**Consultation Response from KC,
Lead Local Flood Authority**

2025/90372 Land at, Edgerton Road, Edgerton, Huddersfield, HD3 3AA

Discharge of details reserved by conditions 6, 7, 8, 9 (drainage), 11 (lighting scheme), 14 (Arboricultural Method Statement), 19 (Construction Method Statement), 21 (estate road), 22 (highway works), 23 (boundary treatments) on previous permission 2017/91916 for variation condition 23 (highway works) on previous permission 2014/93014 (APP/Z4718/W/15/3002523) for outline application for residential development comprising of 41 dwellings plus associated works (within a Conservation Area)

Date Responded: 17th April 2025

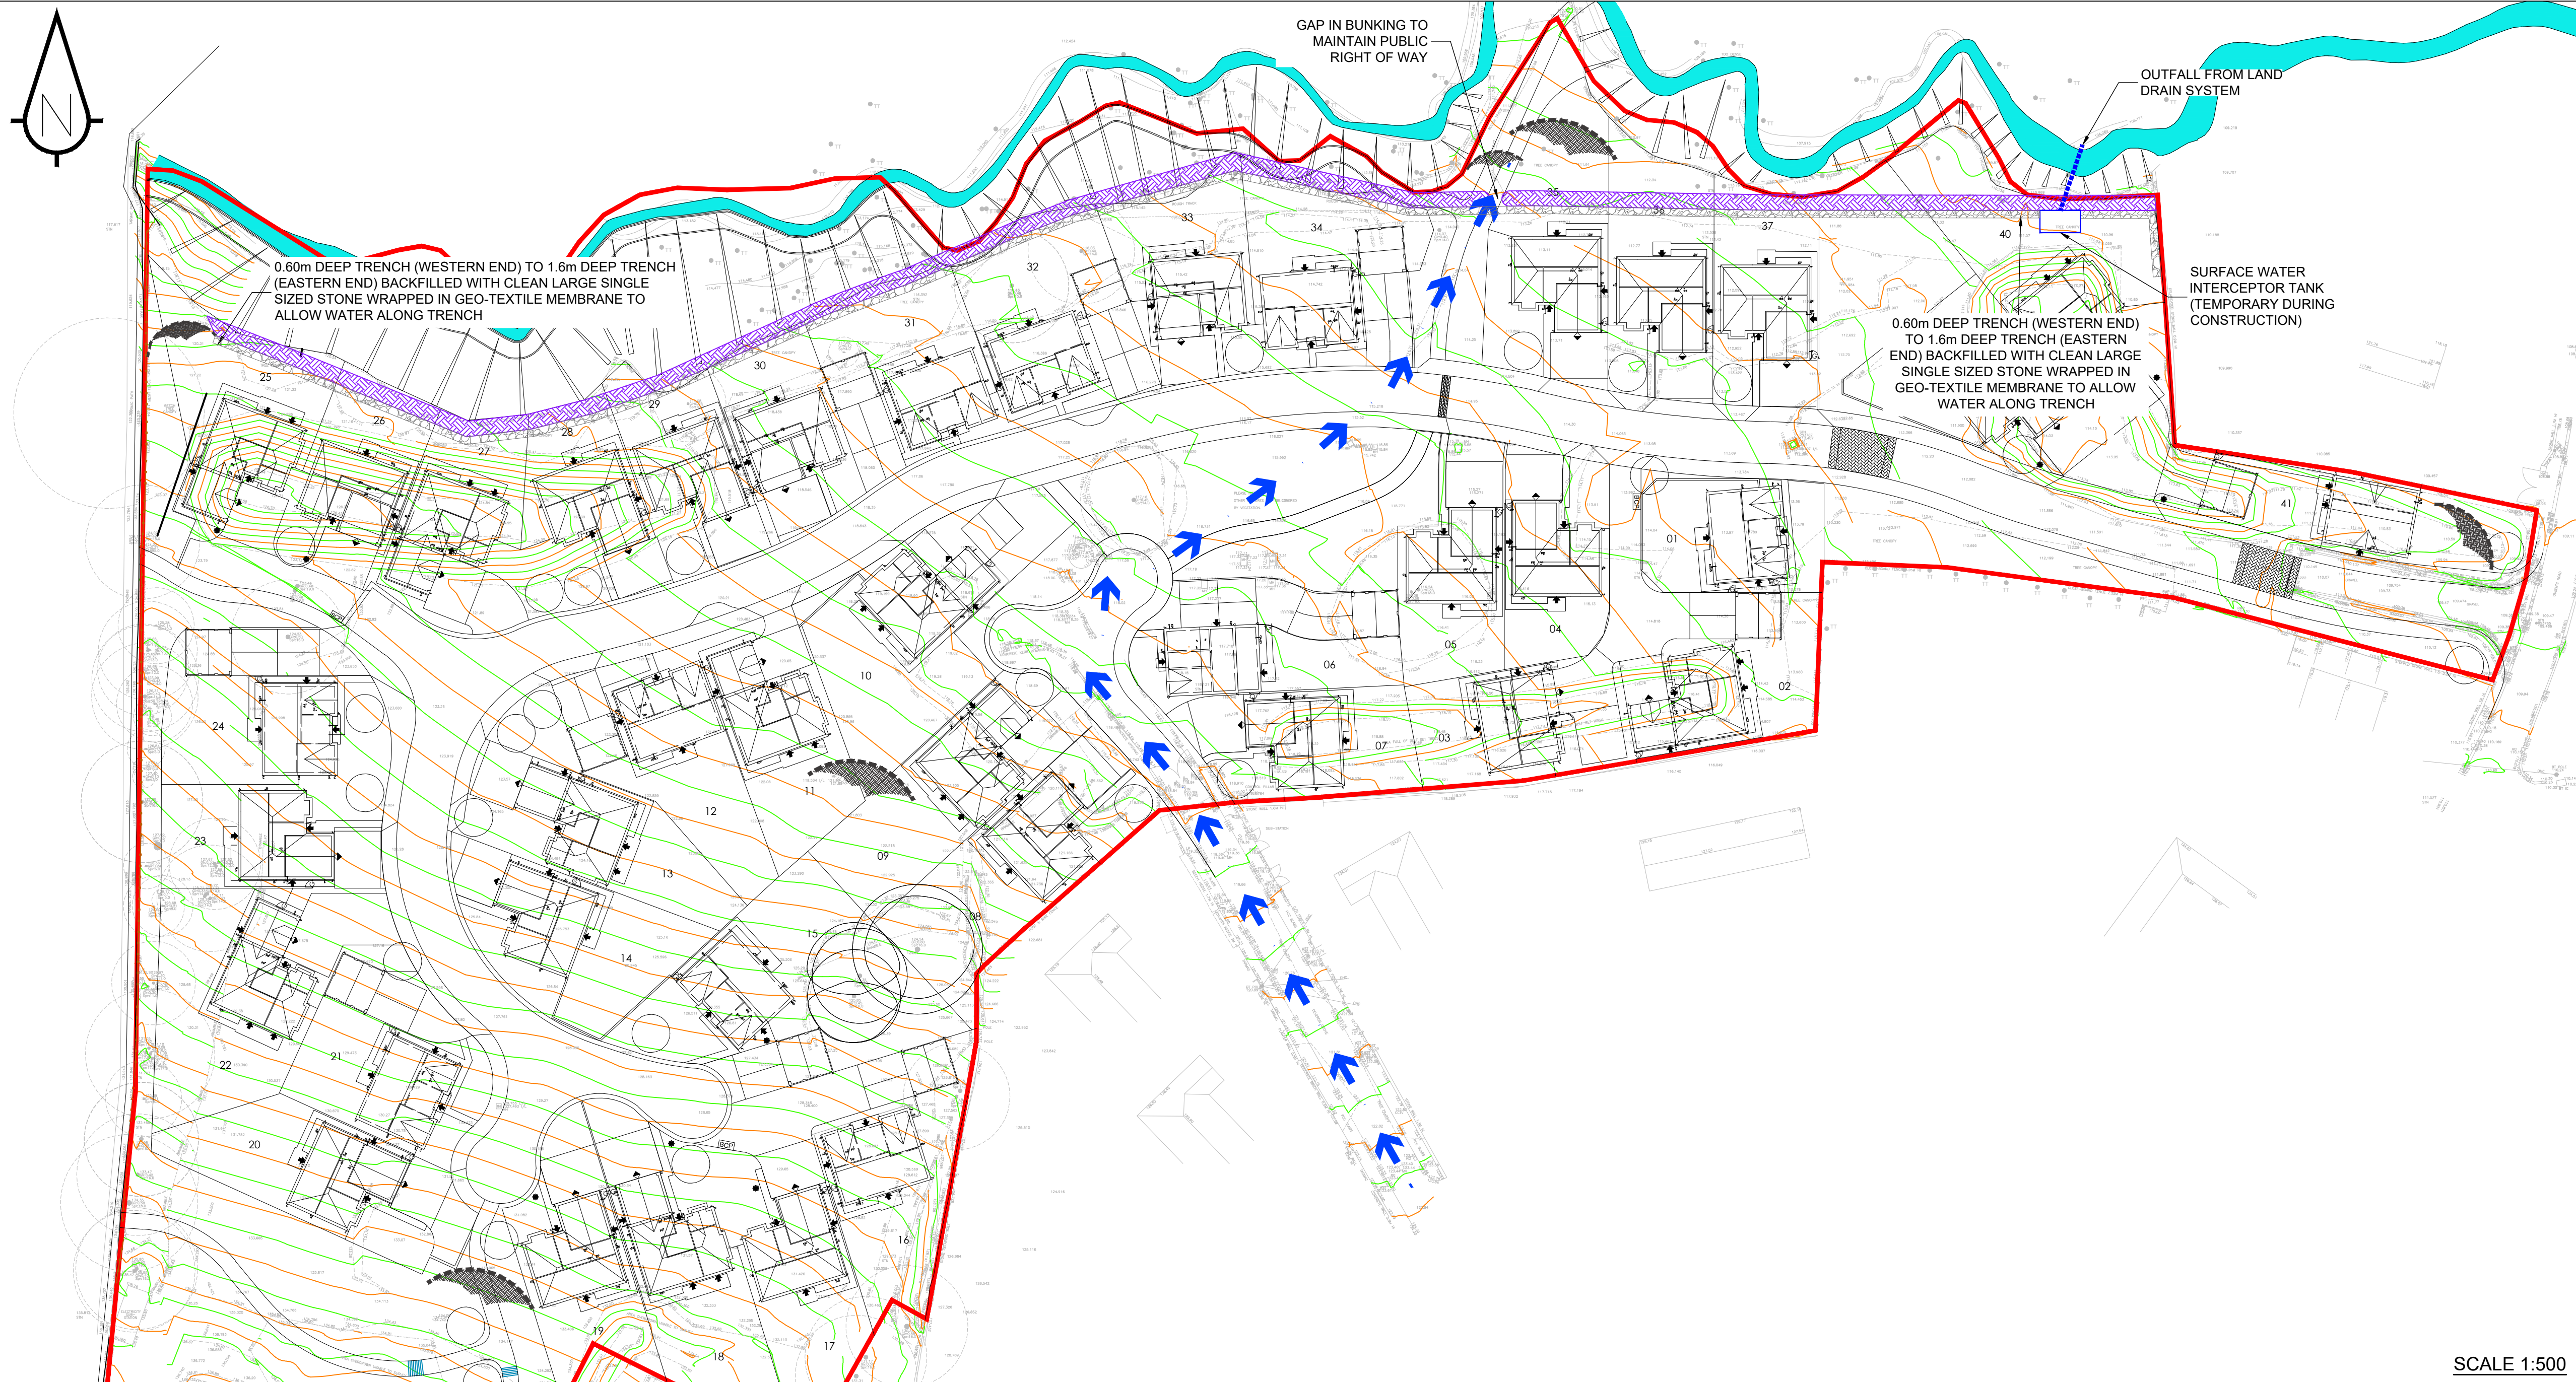
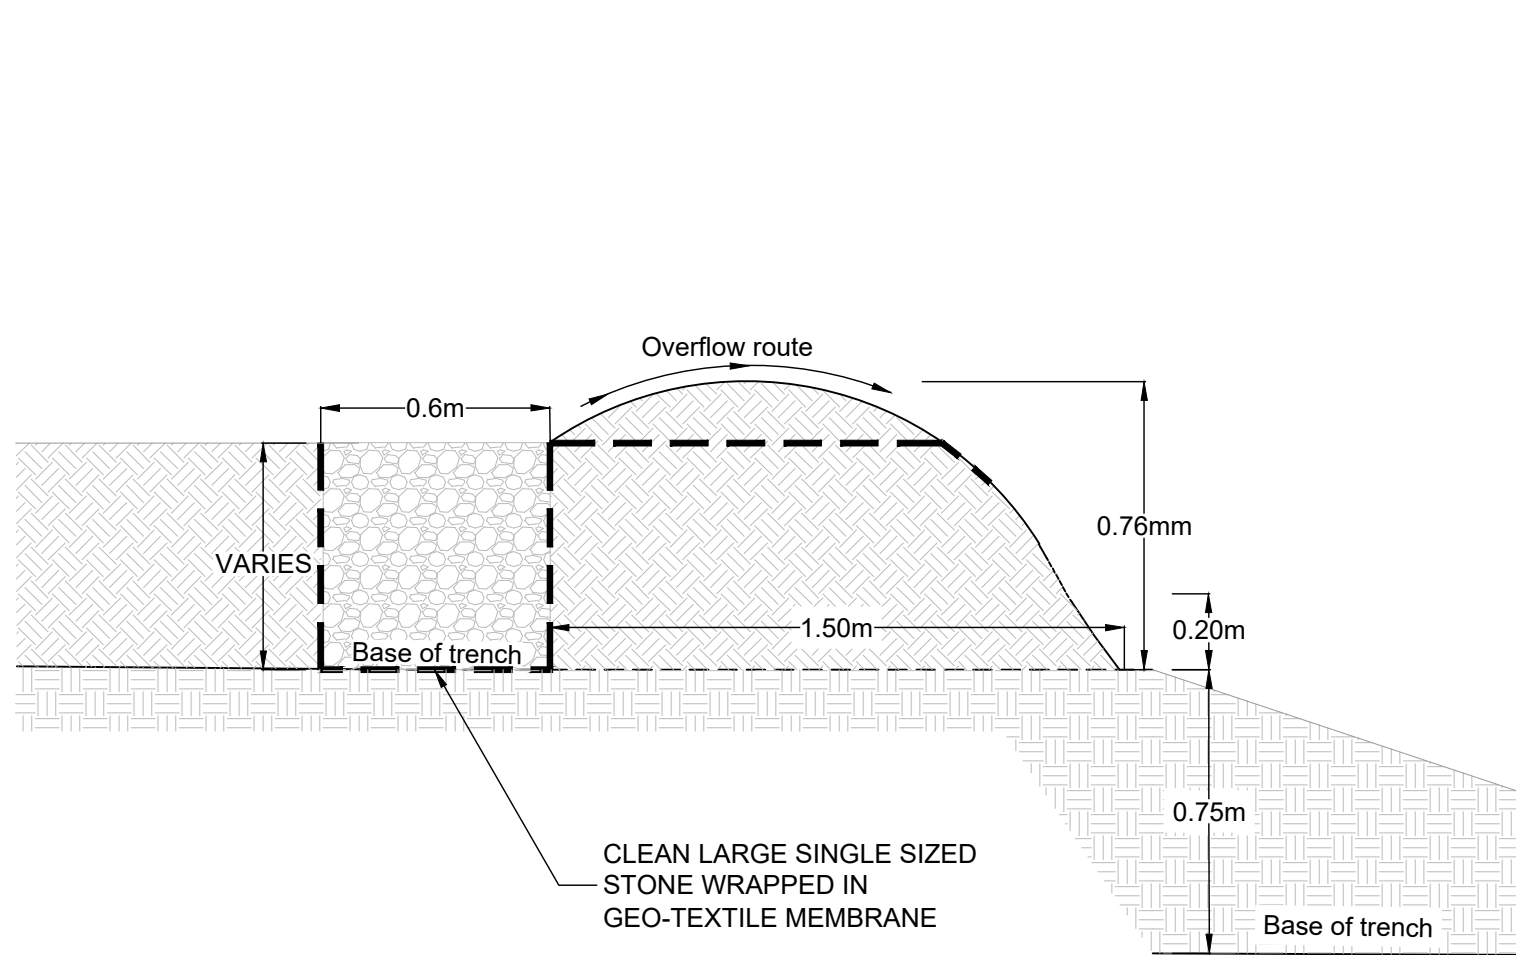
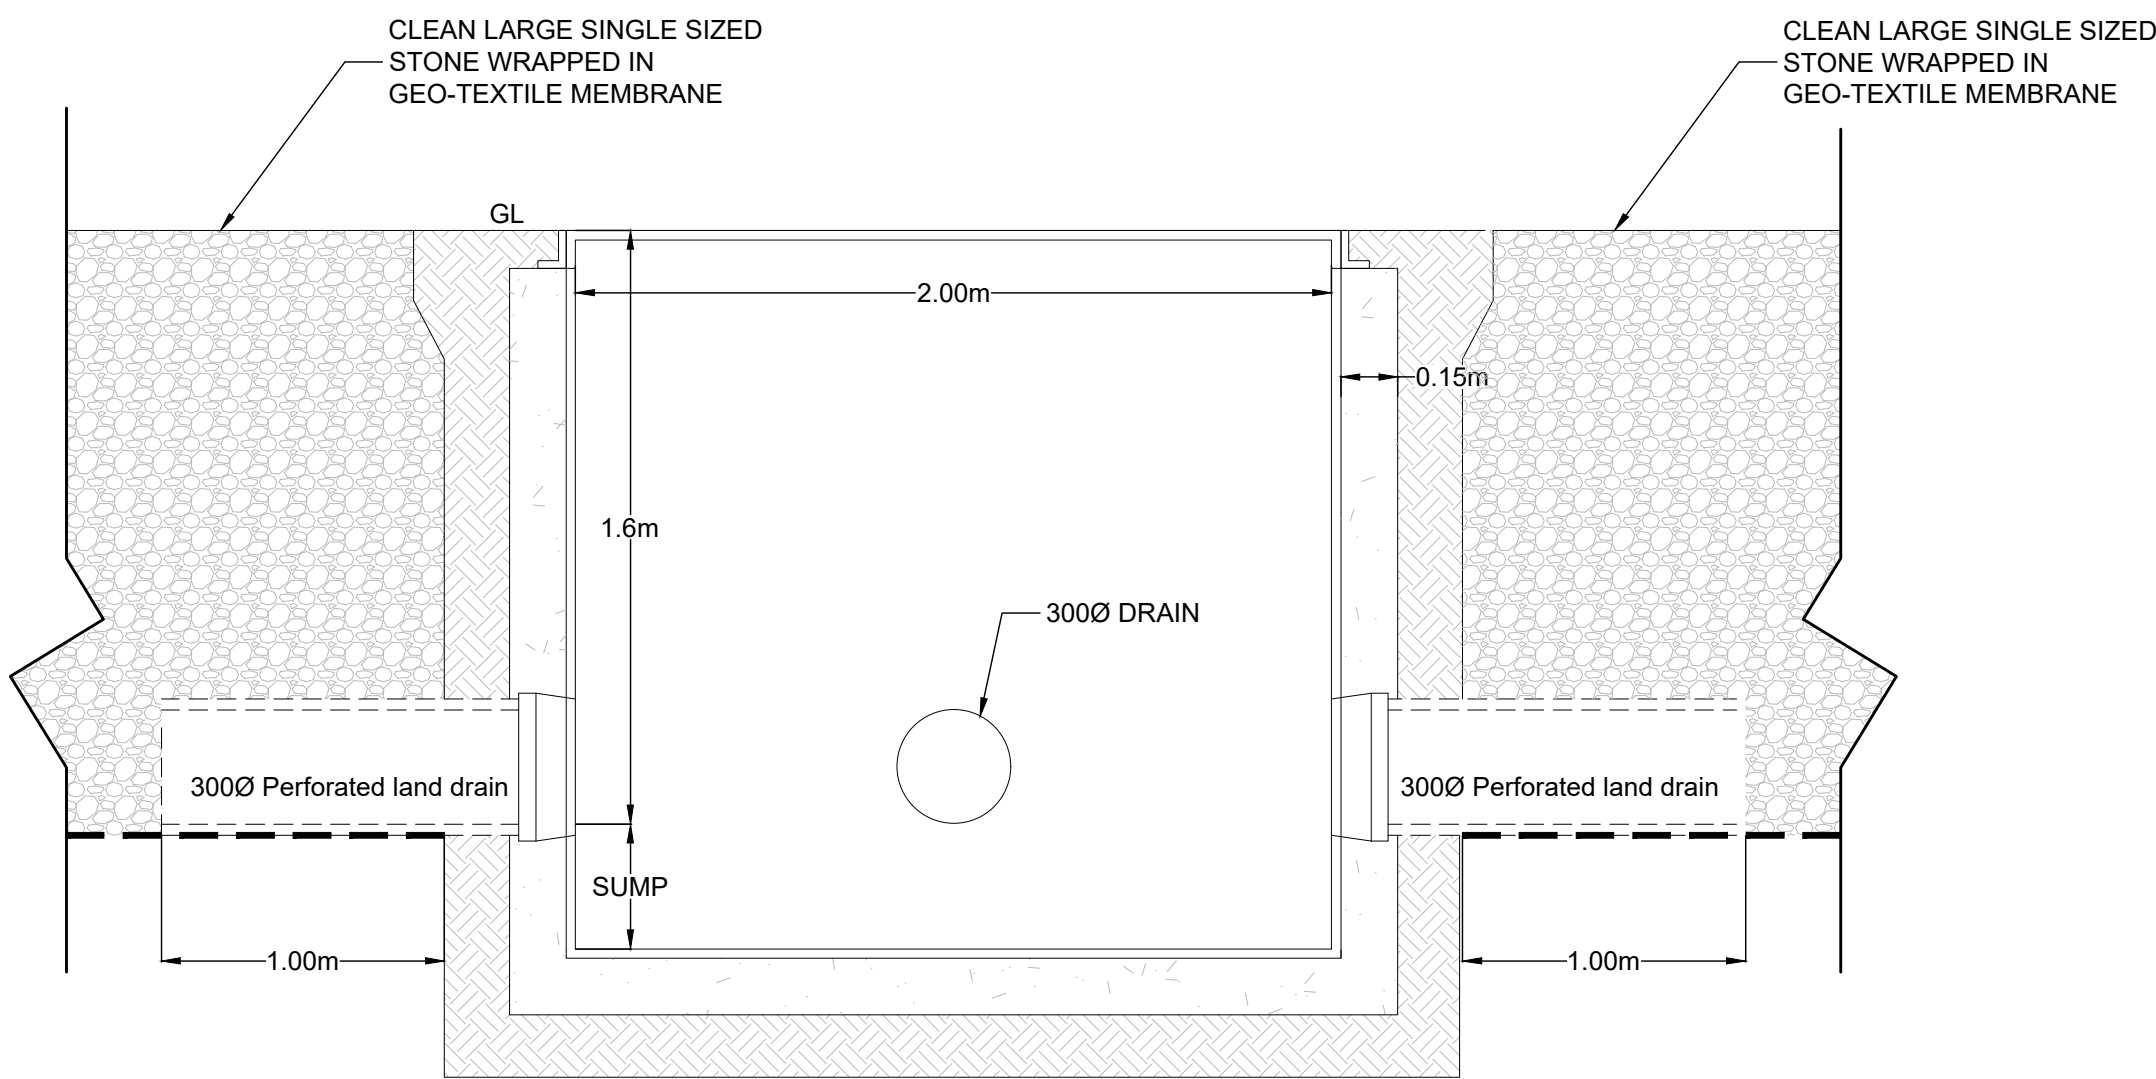
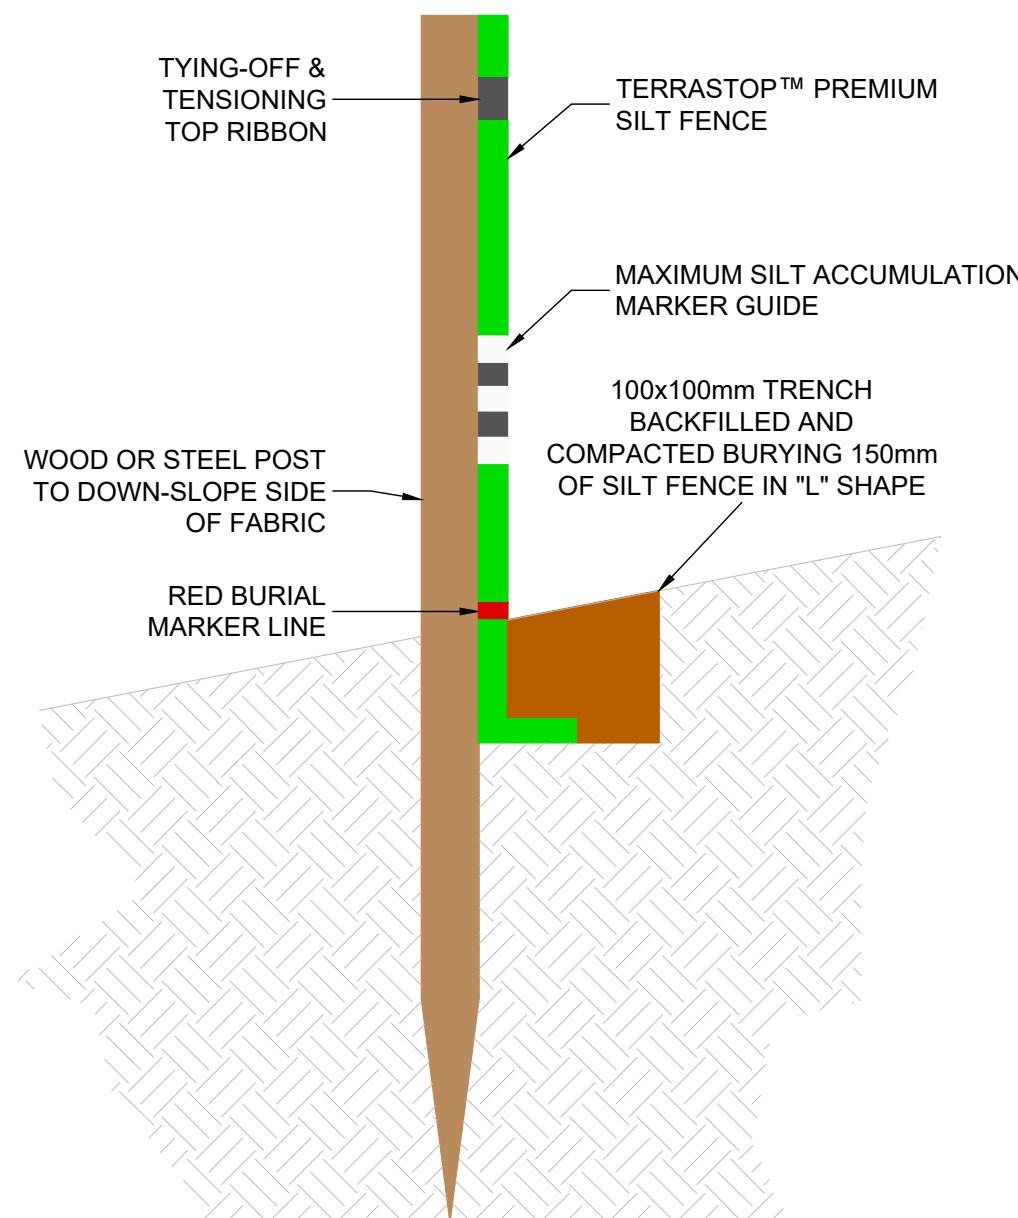
All previous comments regarding the discharge of drainage conditions apply. The construction phase drainage plan is still not robust enough and should follow the advice previously given.
